Rezoning Transportation Analysis

Petition Number: 2023-177

Date	Description
1-24-24	First Review (IW)

RZ.01

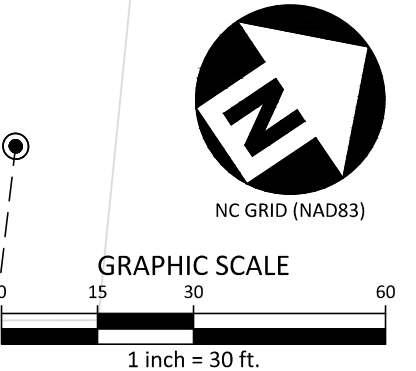
- a. **Gibbon Road:** Location of back of curb and gutter to be moved 19' from centerline.

- b. **Easy Street:** Location of back of curb and gutter needs to be installed and moved 25.5 feet from centerline.

Label and dimension the curb and gutter from the centerline for each road on the site plan.

3. Revise site plan and conditional note(s) to commit to dedicate 39' of right-of-way from the Gibbon road centerline. The site plan shall label and dimension the right-of-way from the road centerline.

4. Revise site plan and conditional note(s) to commit to dedicate 31.6' of right-of-way from the Easy Street road centerline. The site plan shall label and dimension the right-of-way from the road centerline.

RZ.02

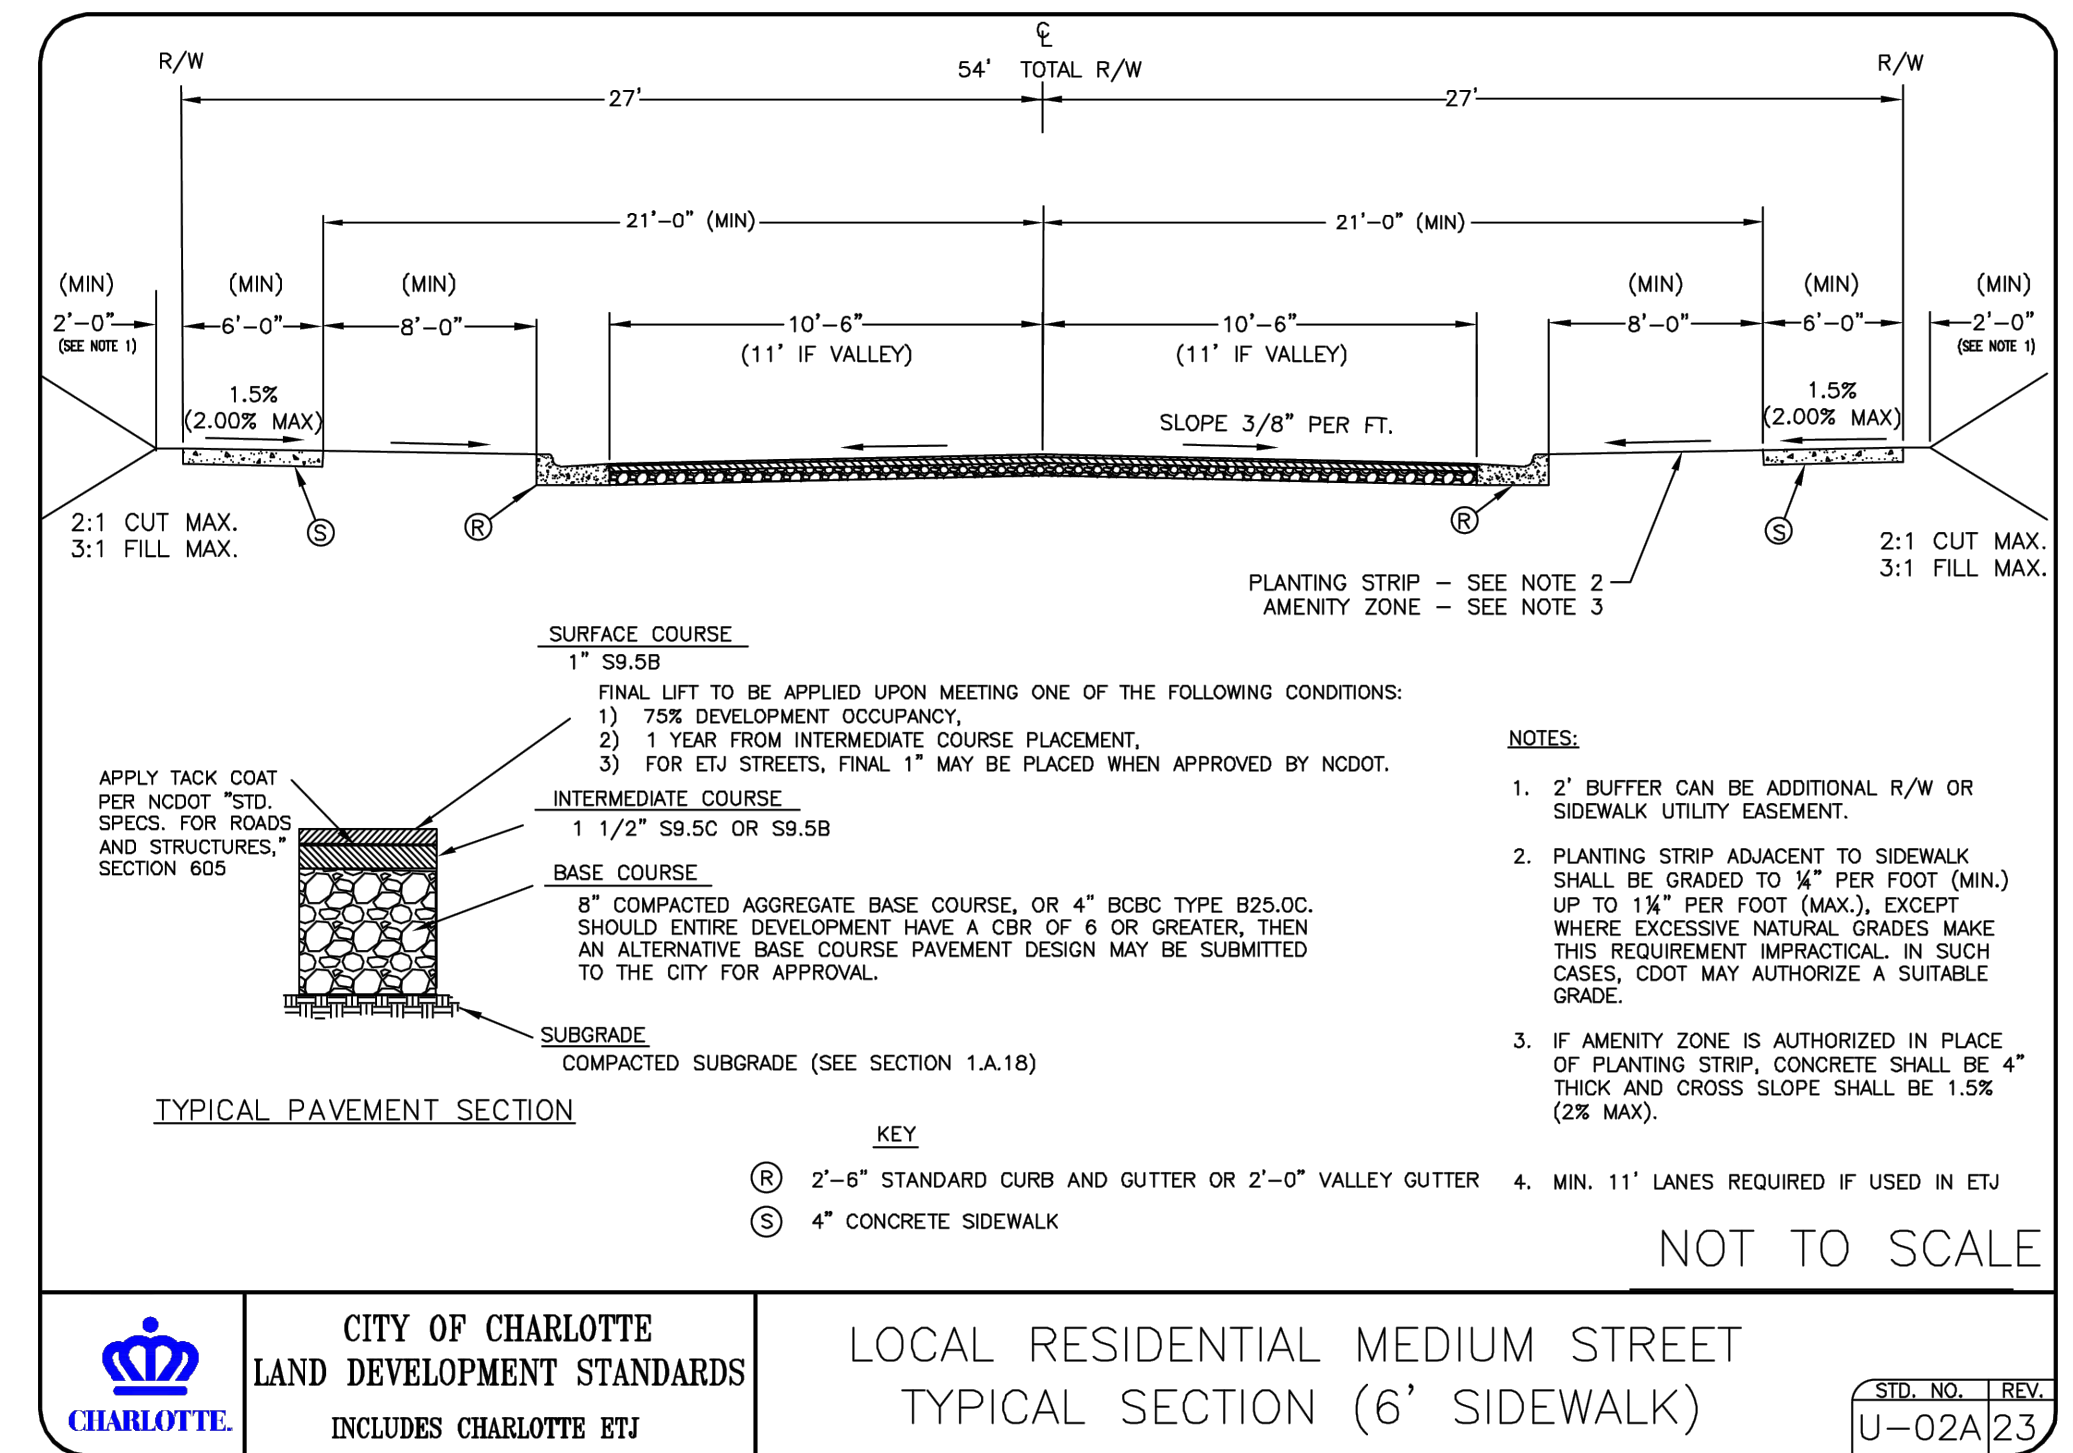
6. Revise site plan and conditional note(s) to update conditional note 3.e. and commit to building Easy Street to a Local Residential Wide Street (CLDSM U-03A2) along site frontage per UDO Article 32 requirement(s).

7. Revise site plan and conditional note(s) to remove labeling related to building Easy Street to a Residential medium standard, as the referenced previously approved rezoning was prior to the new UDO.

8. Revise site plan and conditional note(s) to either remove Conditional note 3.g. OR specifically list how site will be phased and what transportation improvements will be associated with each phase. CDOT will then determine if the request to phase improvements are agreeable.
